# Rezoning Transportation Analysis

Petition Number: 2023-032

Date	Description
7-26-23	First Review (IW)
08-24-23	Second Review (NK)

C:\Users\jrbanks\OneDrive\Dropbox\Banks Engineering\Dropbox\Banks Engineering\Projects\2023\081323\Kings College\DWG\RZ-02 SCHEMATIC SITE PLAN.dwg

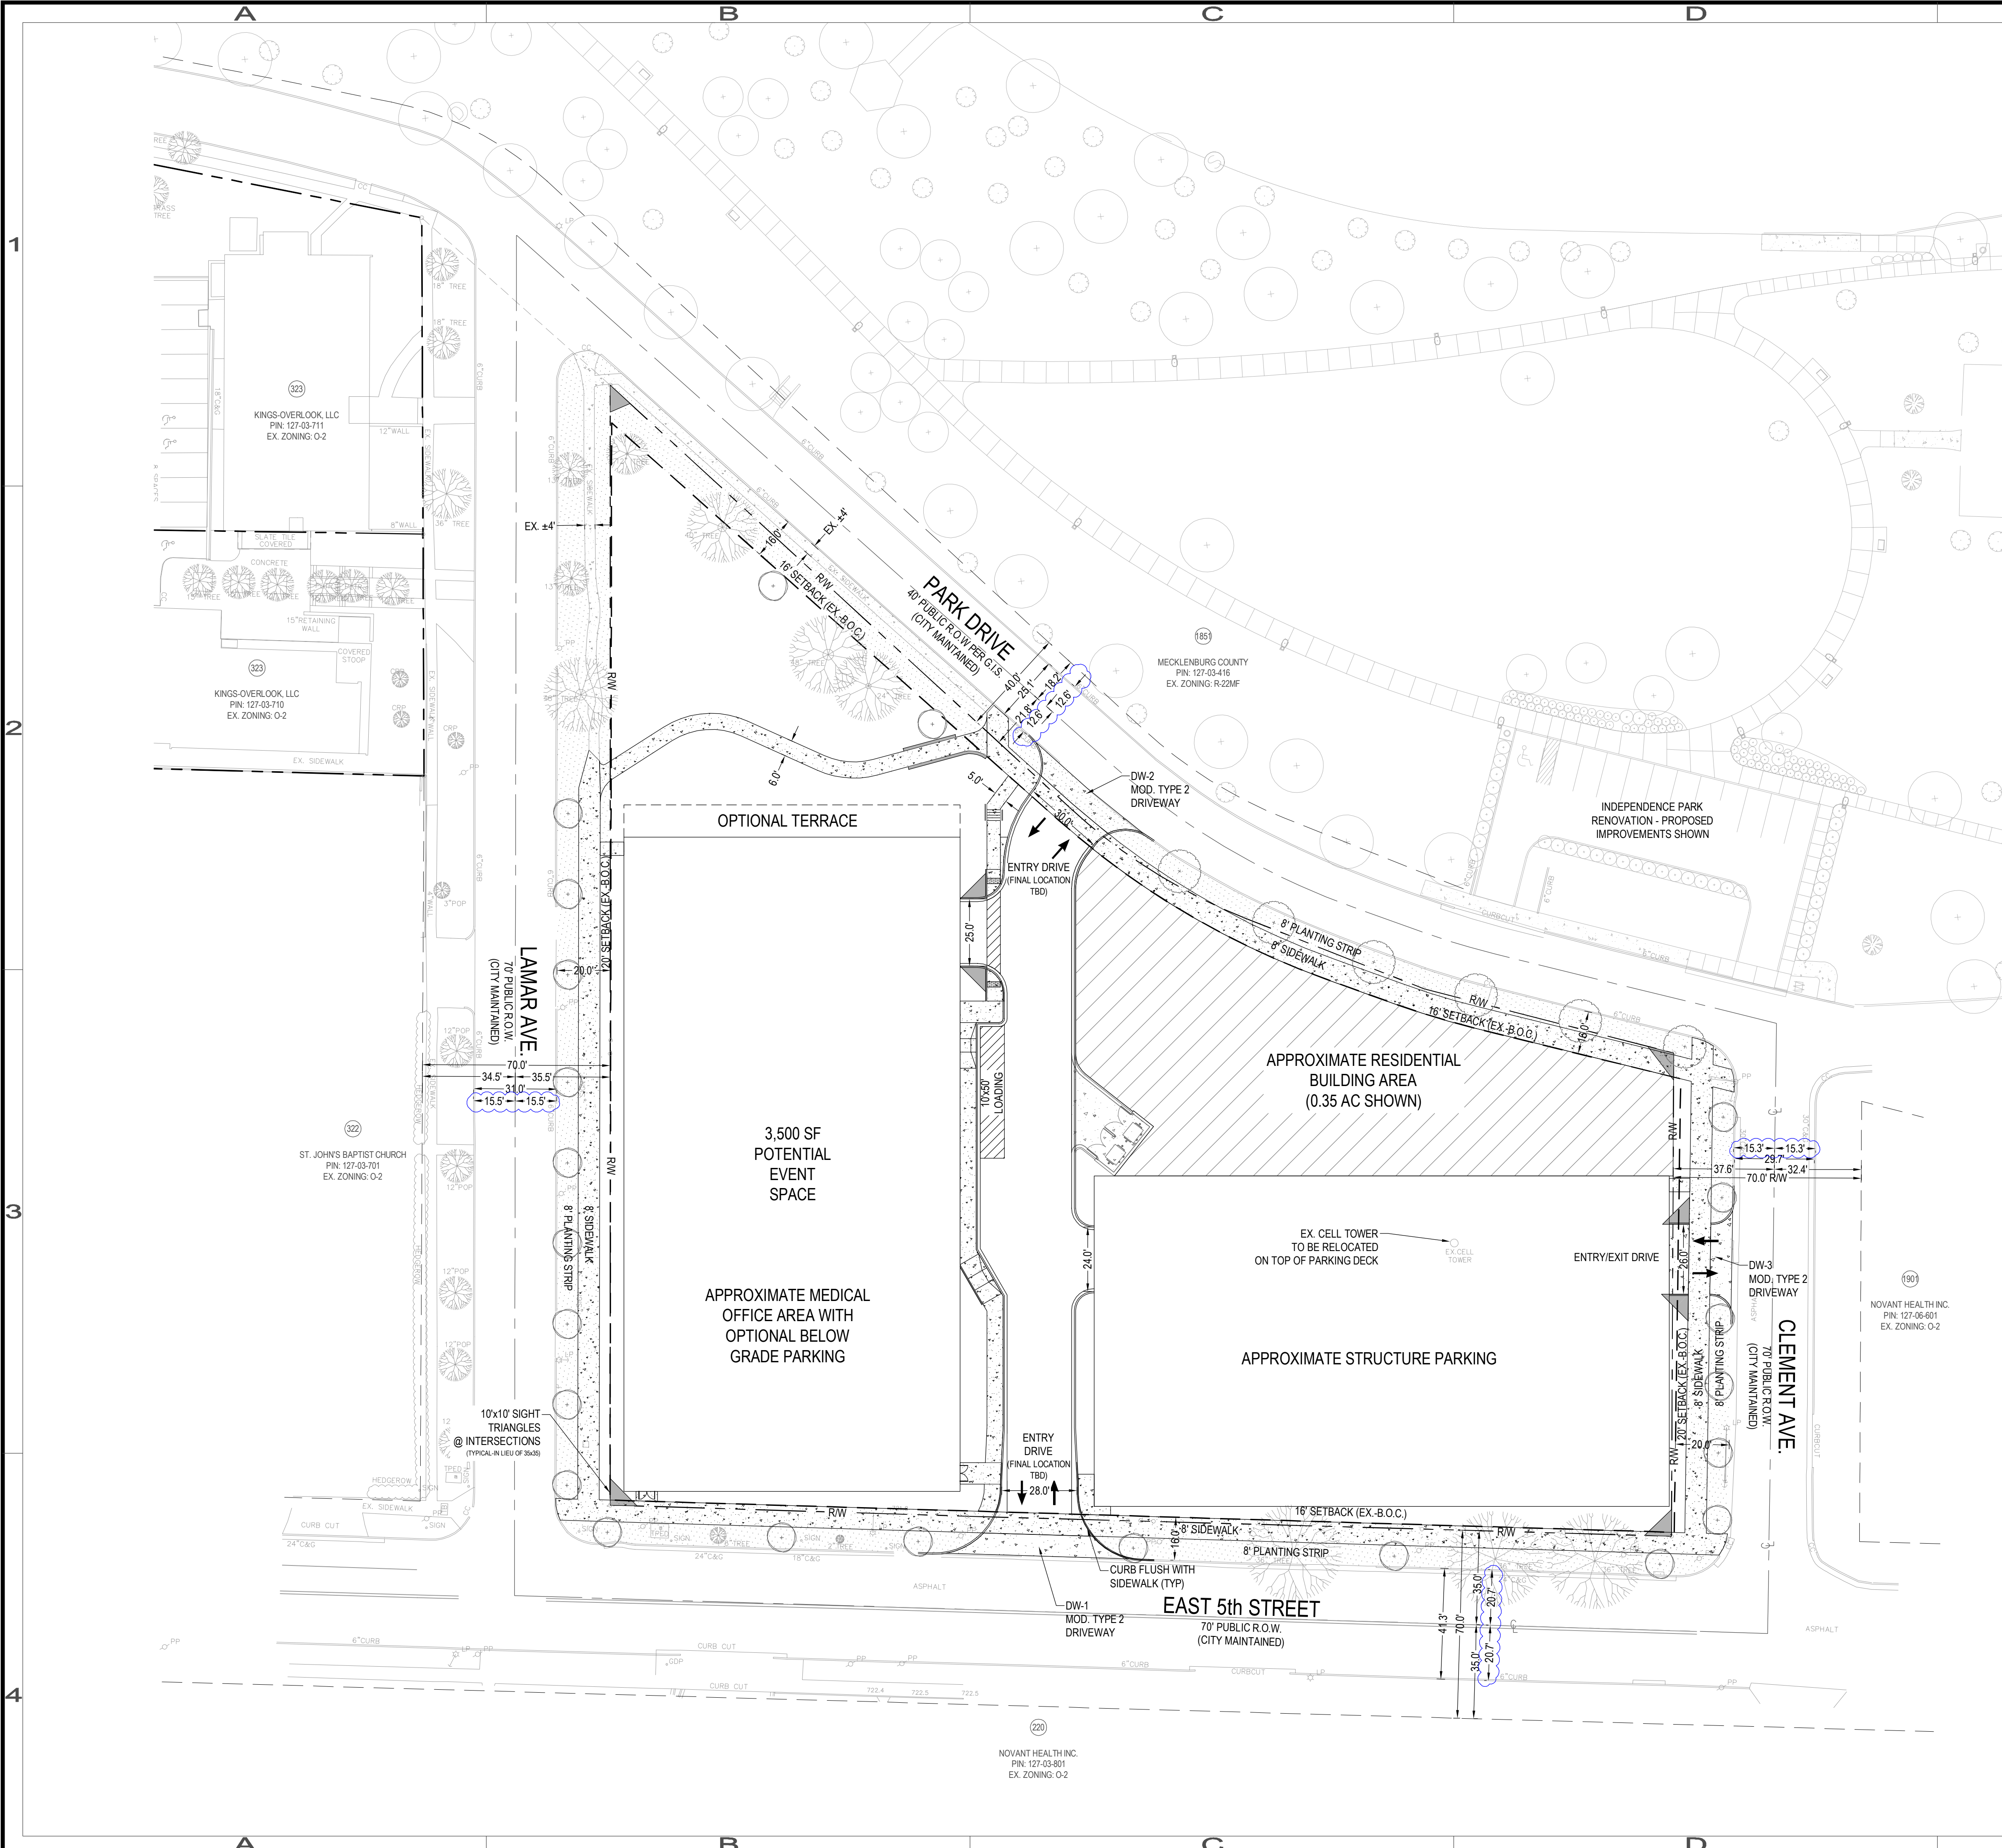
**1. ~~Curbline:~~**

- ~~a. The future location of curb and gutter is in the existing location for all abutting roads and matches previously approved rezoning.~~

~~NOTE: Additional distance from center line to back of curb may be required in locations where a median is present or around intersections and interchanges.~~

~~Label and dimension the curb and gutter from the centerline for each road on the site plan.~~
